Rampion 2 Offshore Wind Farm

**Appendix N3 to the Natural England Deadline 3 Submission**

**Natural England's Response to the Examining Authority's Written  
Questions (ExQ1)**

25 April 2024

Graphic A-2 Indicative illustration of vegetation notched to 6m and showing new planting

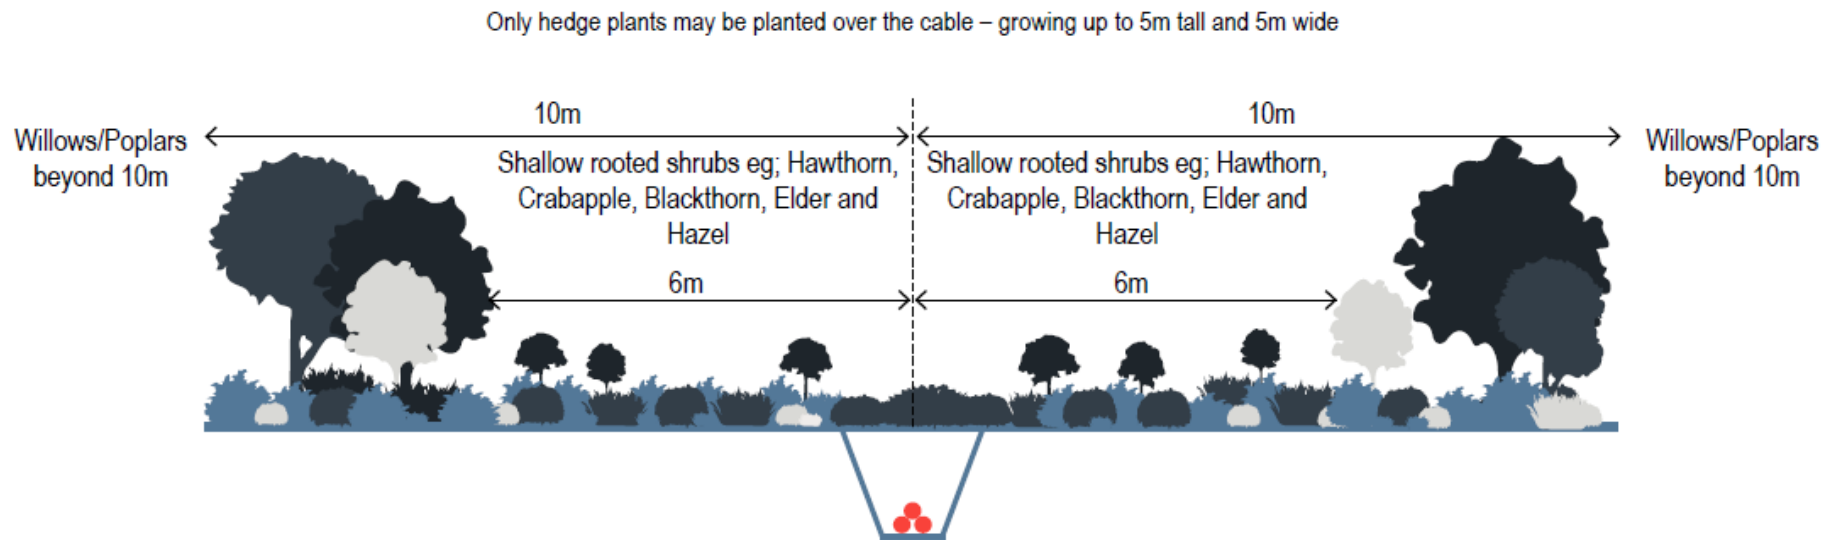
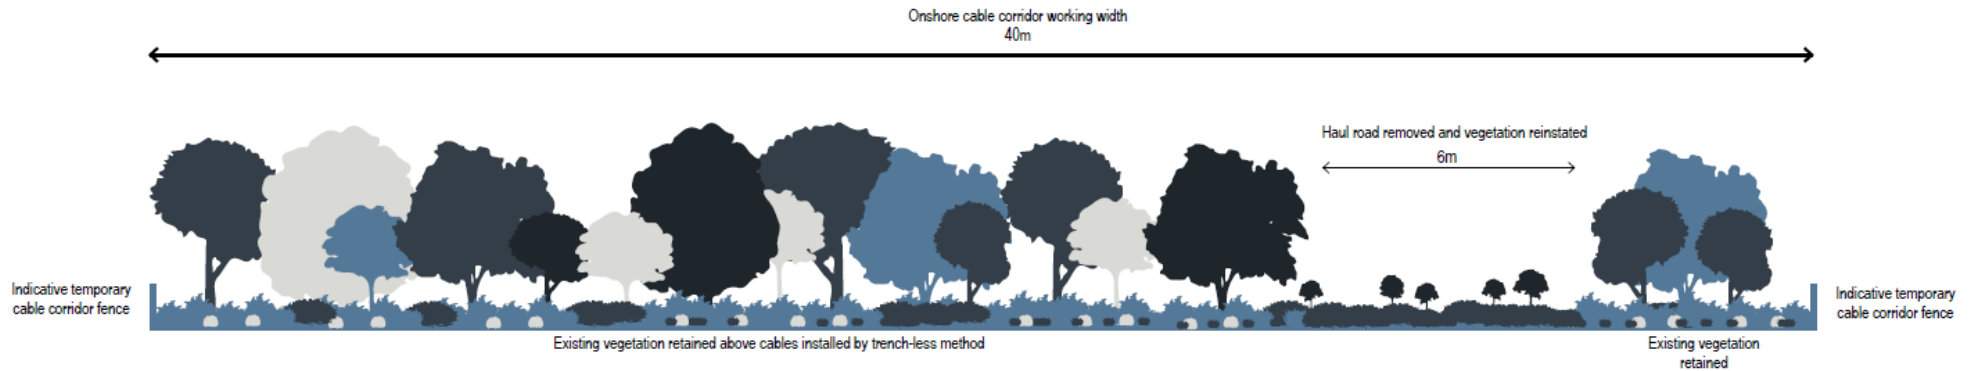
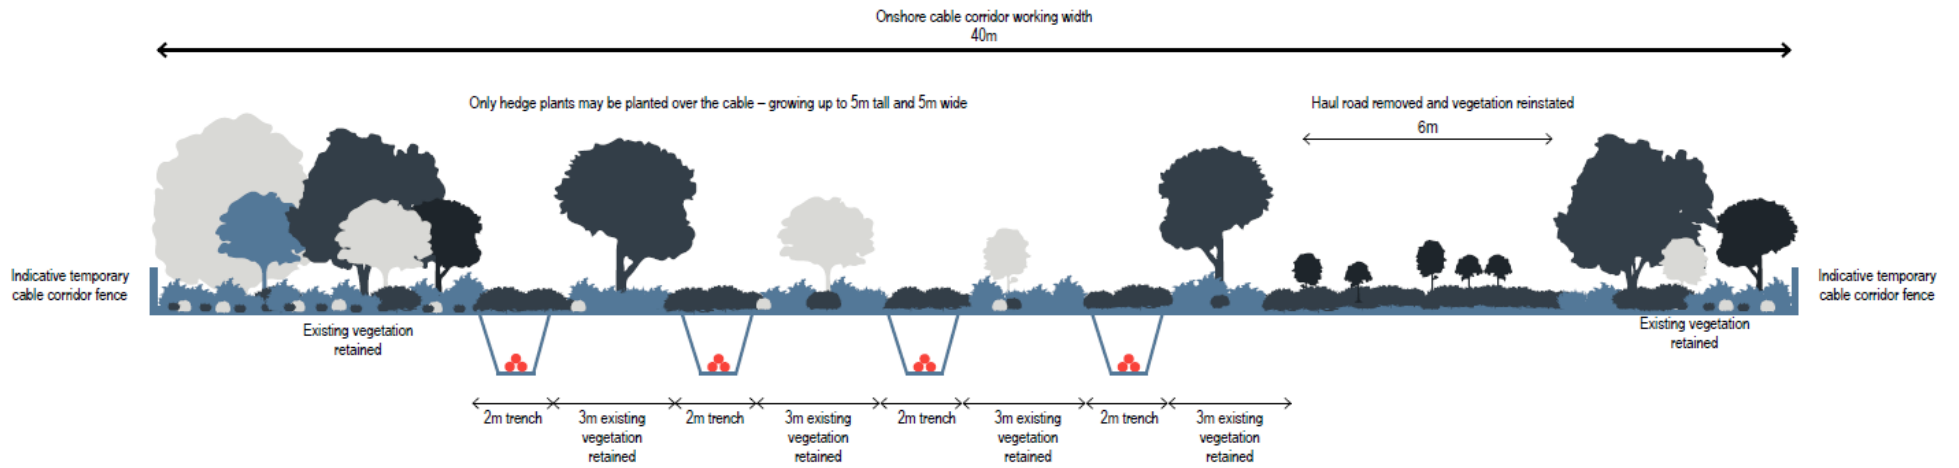
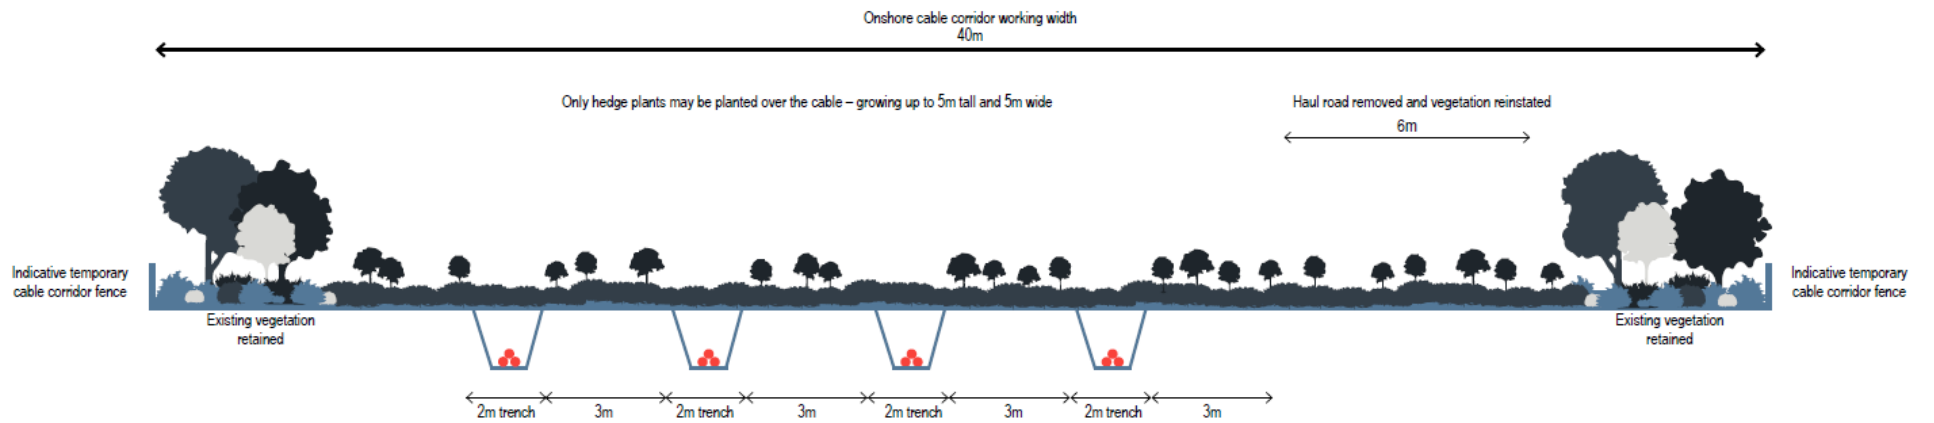
<b>West Sussex CC</b> <b>Forestry Commission</b> <b>Horsham DC</b> <b>Arun DC</b>		
TE 1.31	<i>Applicant's Approach to Hedge Notching</i> <b>Natural England</b> <b>The Forestry Commission</b> <b>The Woodland Trust</b> <b>SDNPA</b>	<p>The Applicant has provided further justification of its proposed hedge notching technique in responses to SNDPA in their PADS [AS-006] and WR [REP1-052], and West Sussex CC's LIR [REP1-054].</p> <p>West Sussex CC commented in their LIR submitted at Deadline 2 [REP1-054] that:</p> <p><i>“Although WSCC has concerns about the success of hedgerow ‘notching’, it recognises that this technique does offer some advantages and therefore is worth attempting provided any necessary remedial measures, such as re-stocking, are implemented immediately.”</i></p> <p>Provide an updated response to the Applicant's proposed hedge noting technique, specifically stating whether there is agreement between the parties or any ongoing areas of disagreement or concern.</p>	<p>Natural England refer the ExA to our advice provided within Appendix J2.5a.</p>
